From: [Nic Wall](#)
To: [Bennett, Sophie](#)
Cc: [Jo Wilkins](#); [Jo Manley](#); [Linda Hayden](#)
Subject: RE: A303 Sparkford to Ilchester Dualling - Non-material amendment Hazlegrove House RPG
Date: 23 April 2019 15:32:00

**Proposed non-material amendment related to Pond 5, access track, fencing
& Hazlegrove School access**
Response on behalf of South Somerset District Council
23rd April 2019

WORK NO.94 - POND 5 (SECTION 5A)

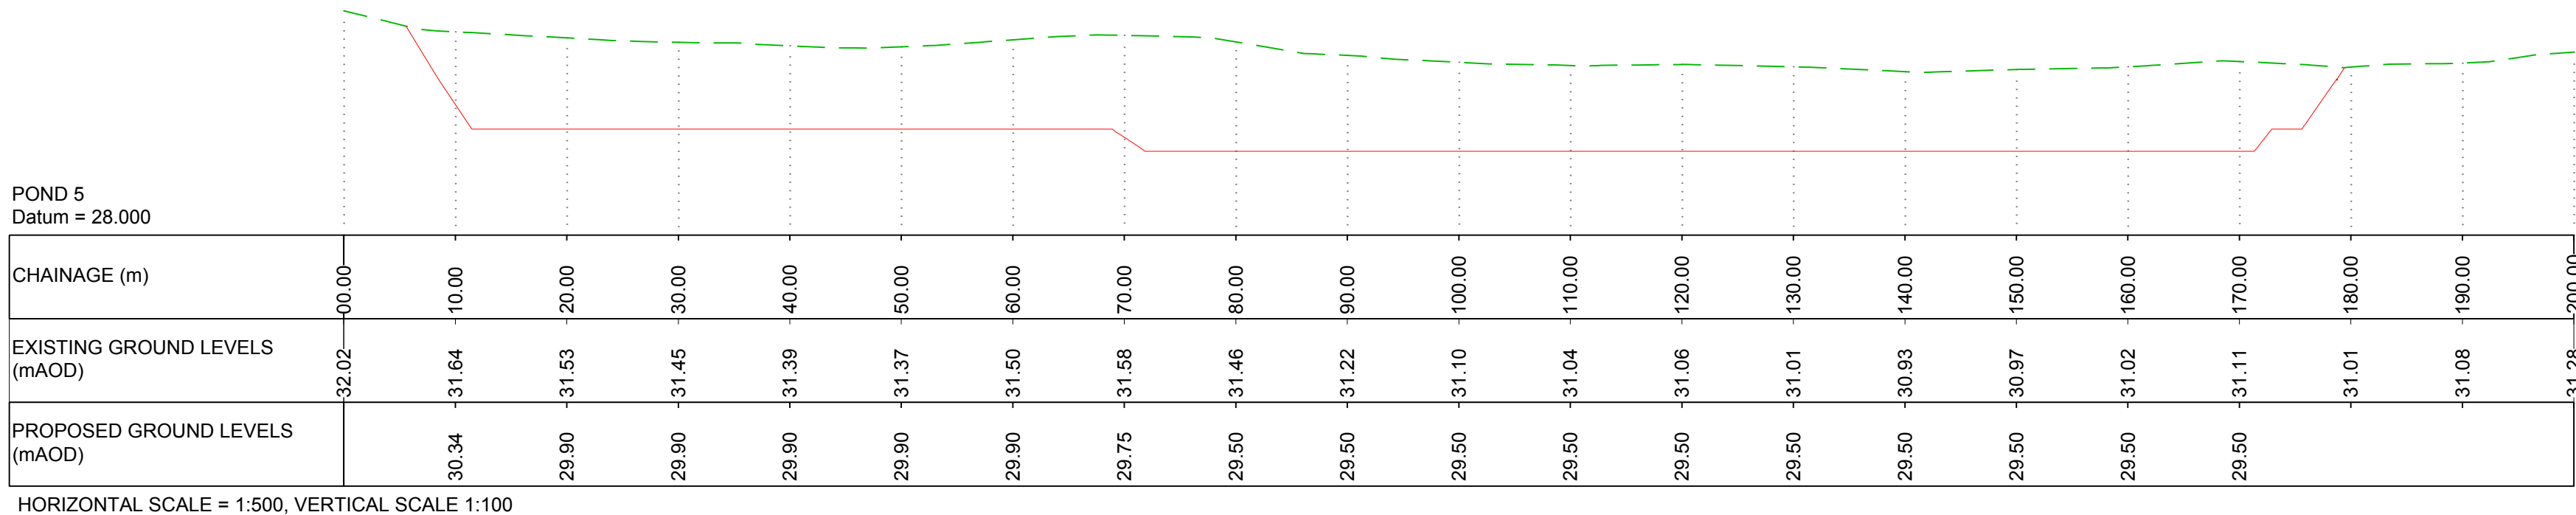
The Council maintains its objection to the location of Pond 5, the inclusion of a pond maintenance track in the RPG, and the segregation of the pond area from the remaining RPG with a new fence.

These three elements of both the existing and amended design are key factors in making the area of Pond 5 a substantial and distinct area of 'highway infrastructure' within the RPG.

The relocation of Pond 5 is resisted by Highways England on the grounds that there is no other suitable location "that is outside the RPG and inside the DCO boundary" (see HE Response to ExA Q2.1.2). The DCO boundary being the hindrance.

It's highly regrettable that opportunities to remove the harm from these three elements of Pond 5 are thwarted by the DCO application process and timeframes, and future management considerations, rather than by site or design constraints.
